From: Anita Gardner
Sent: 24 October 2018 14:53
To: Planning.Responses
Subject: FW: LU/223/18/pl 36-38 Surrey Street, Littlehampton

From: Anita Gardner
Sent: 24 October 2018 14:52
To: Emma Weaver [REDACTED]
Subject: LU/223/18/pl 36-38 Surrey Street, Littlehampton

Proposed Floor Plans

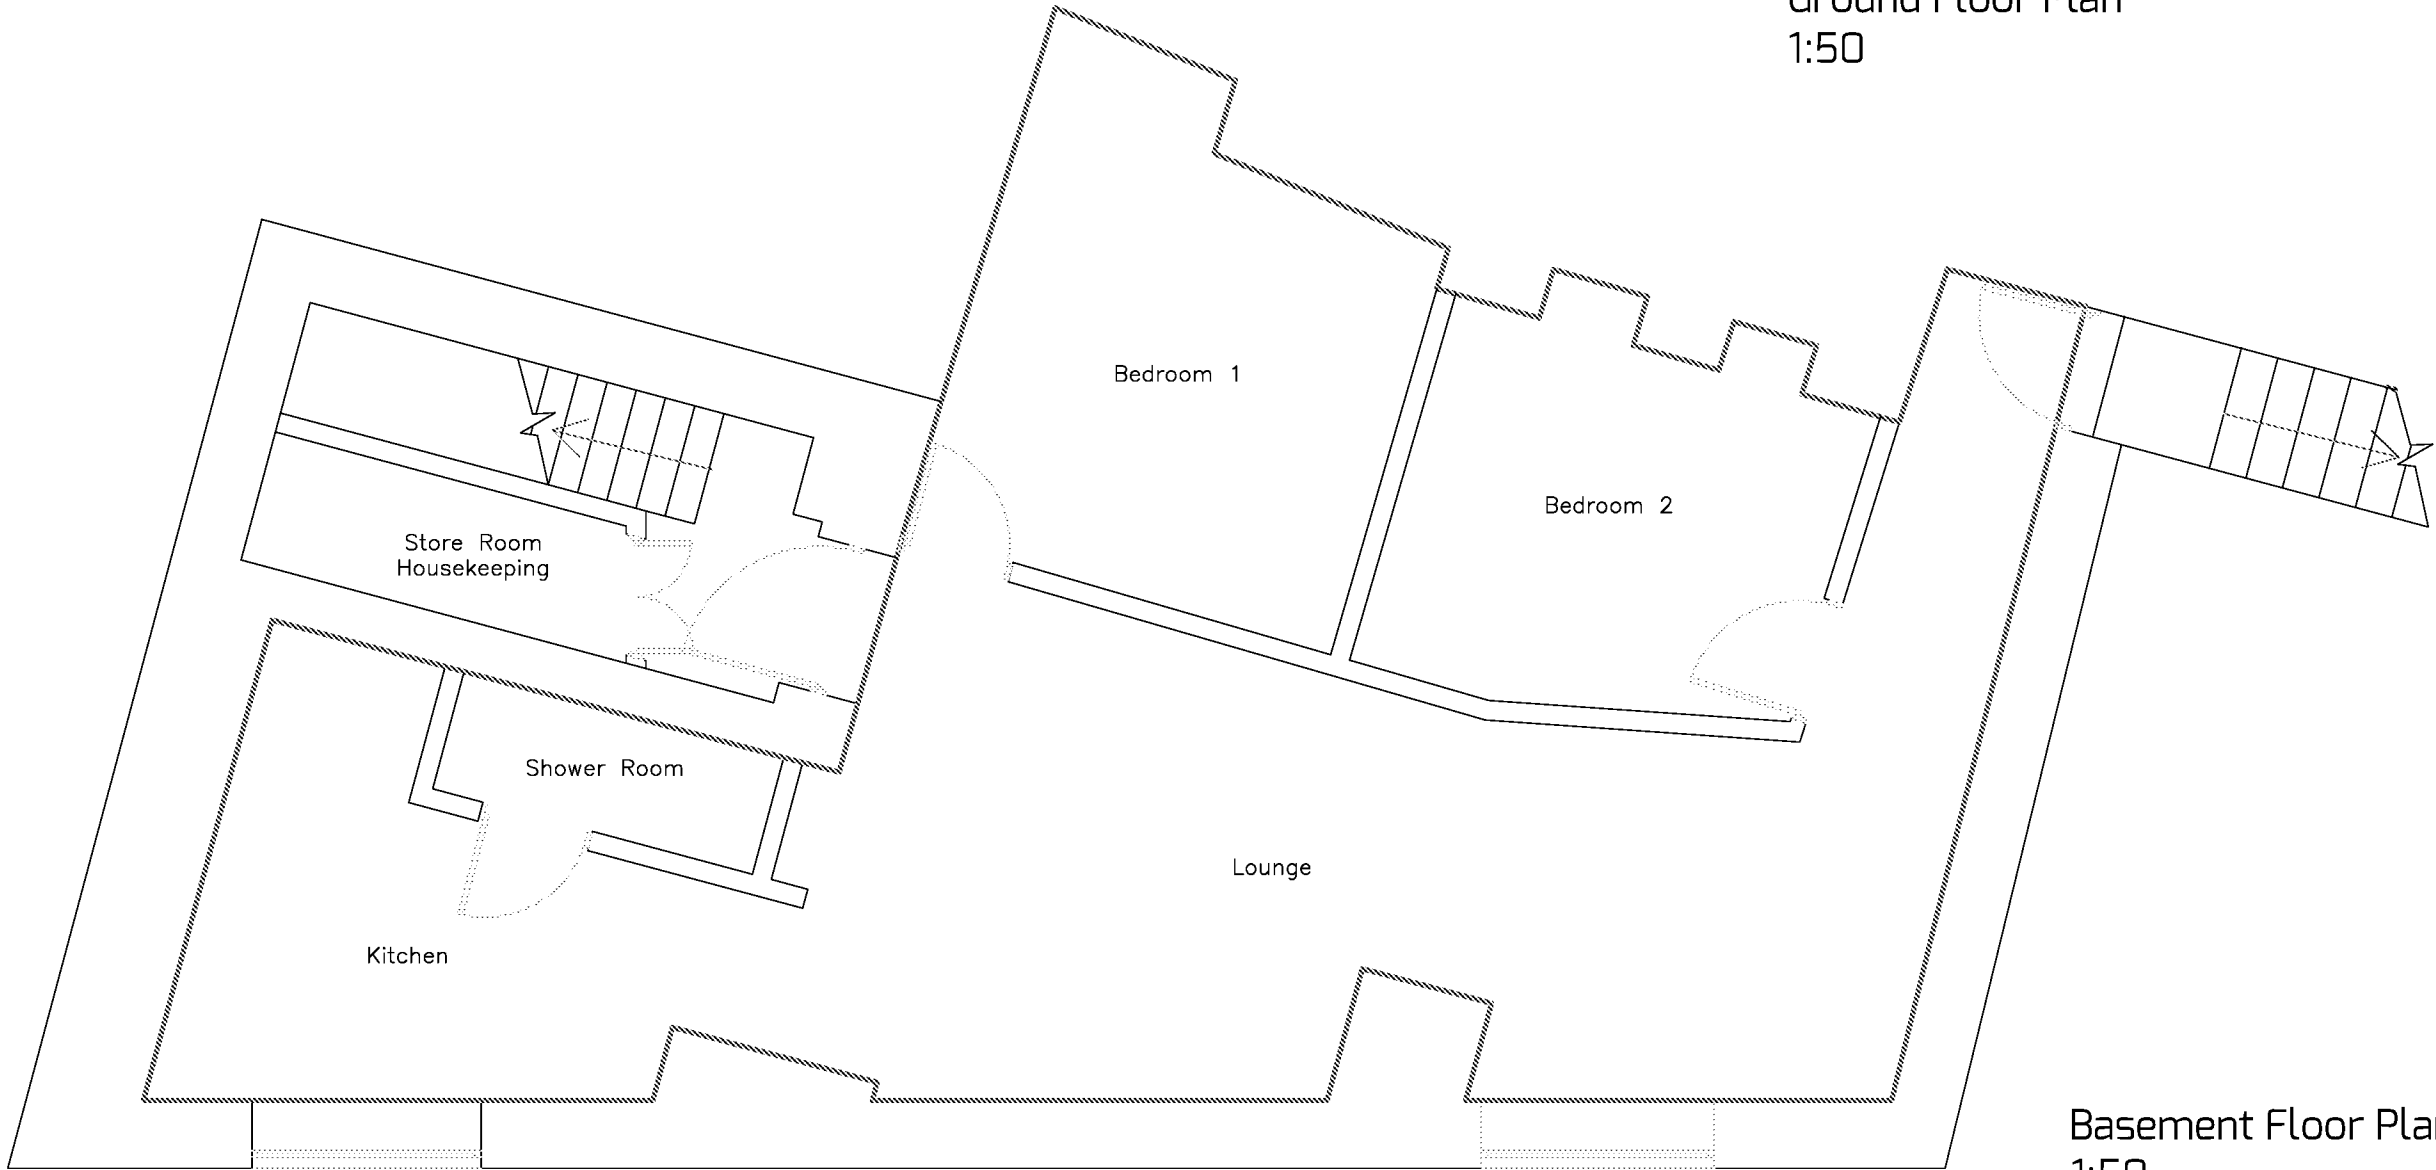
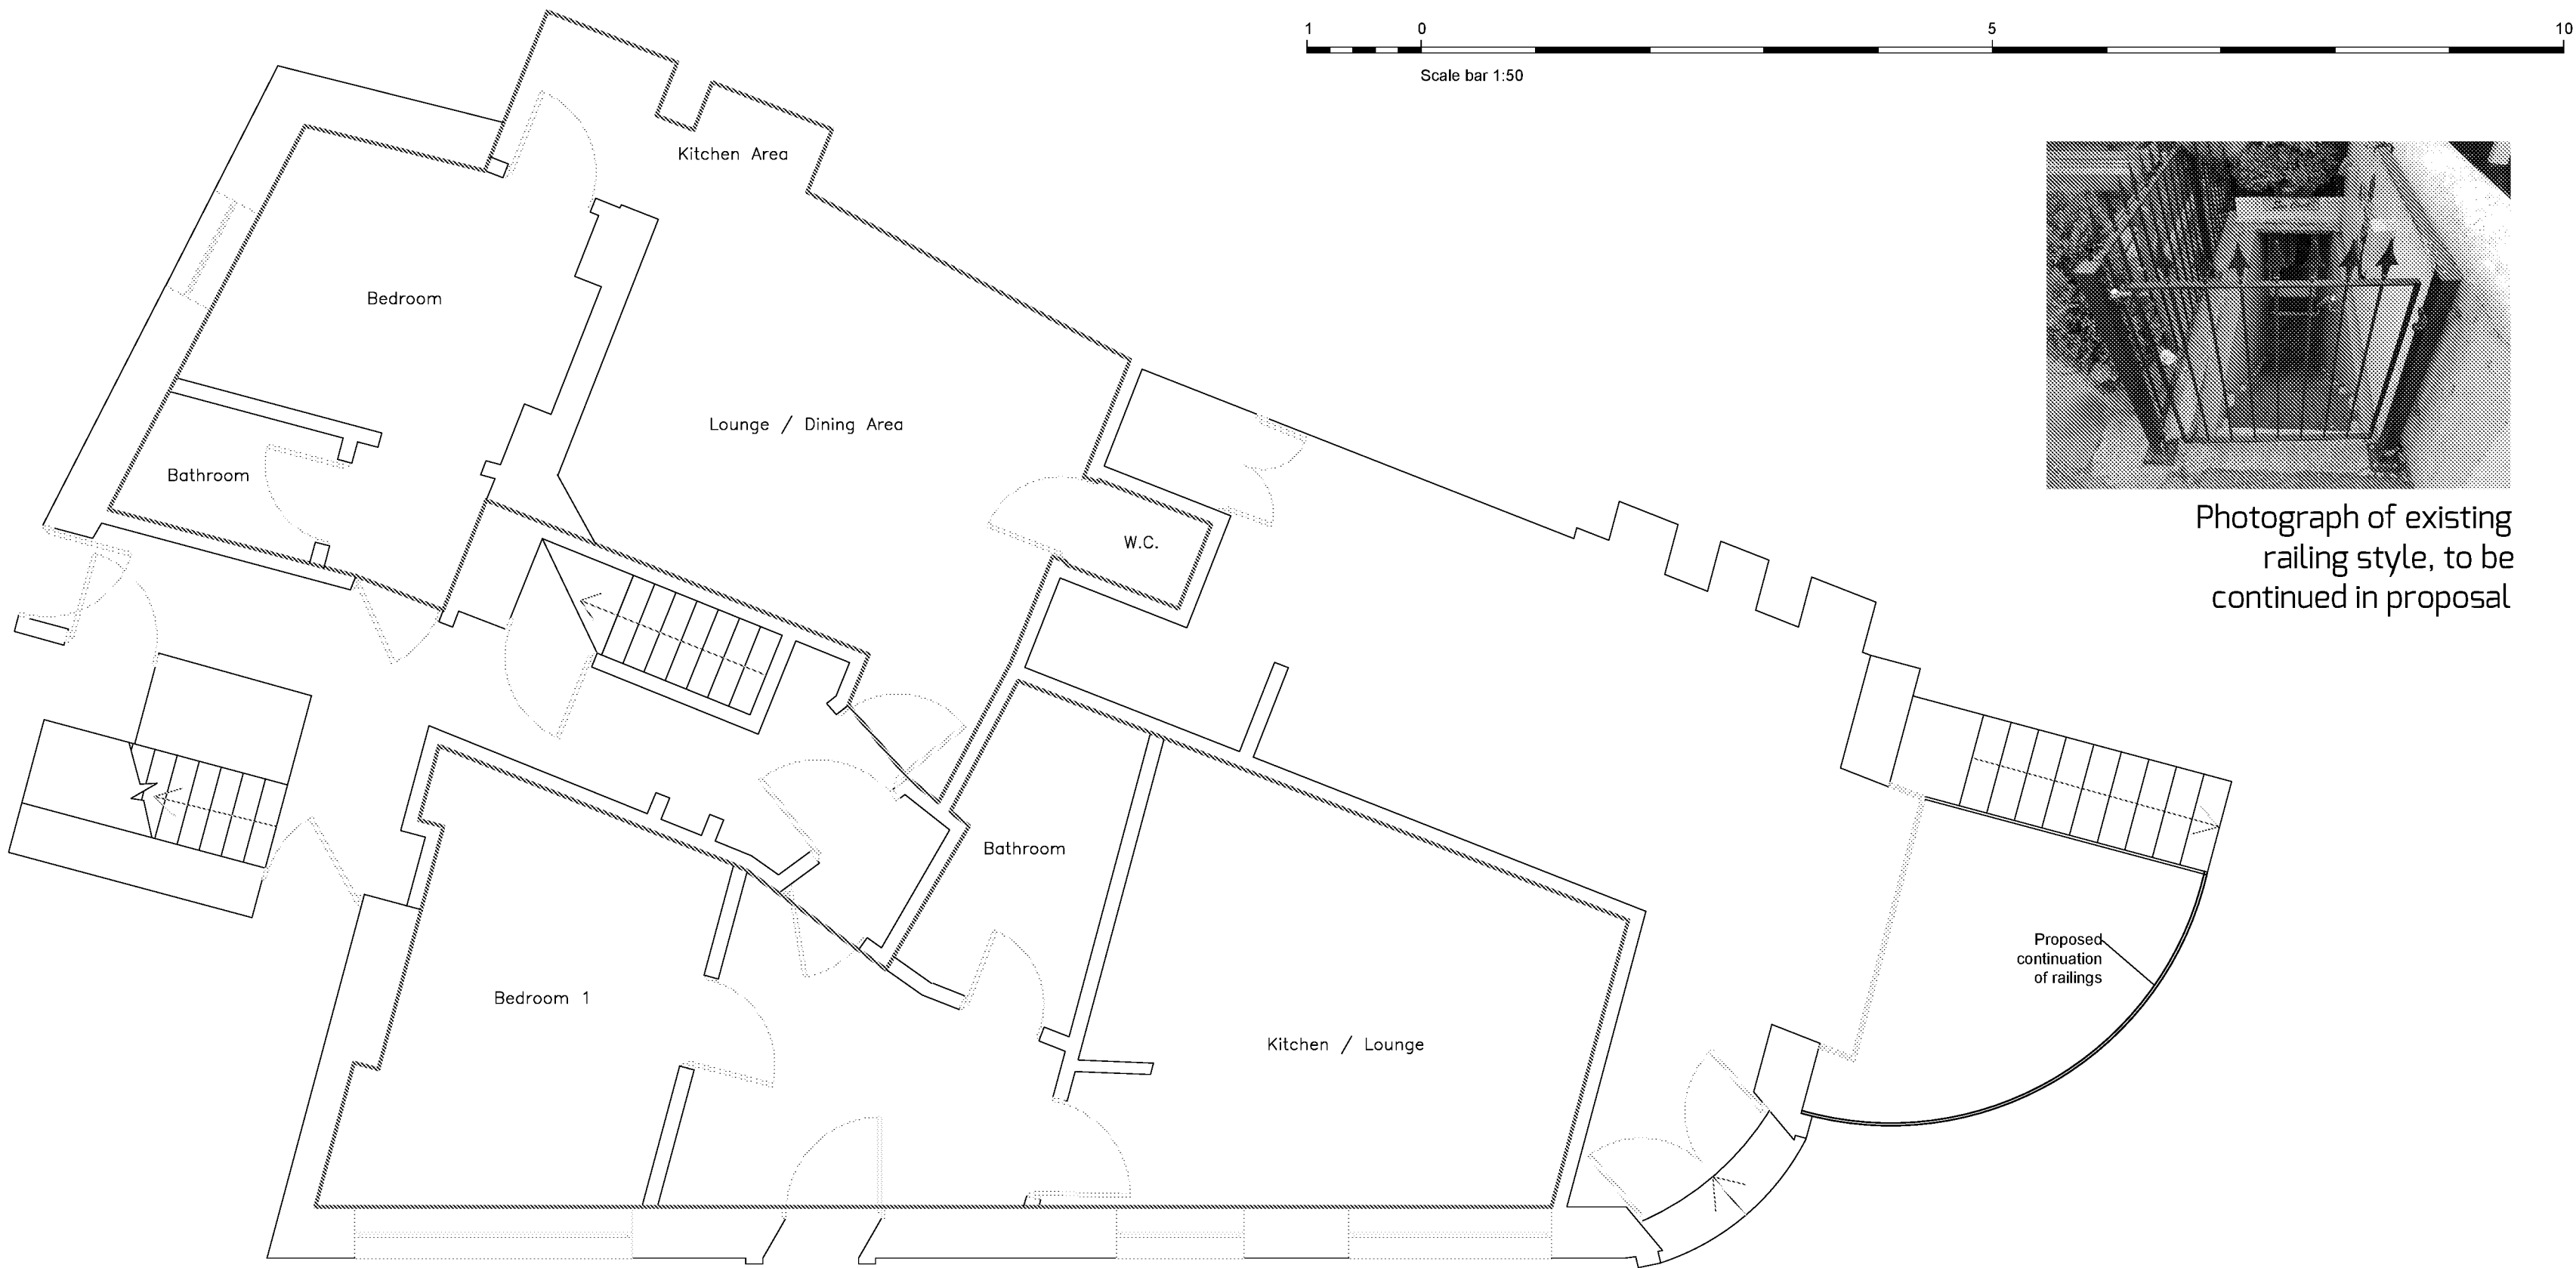
I also note that the railings at ground floor level are not included in the application description and if they remain part of the application the description will need to be amended to include them and submission of further details and discussion with the Conservation Officer will be required. This alteration may require re-advertising.
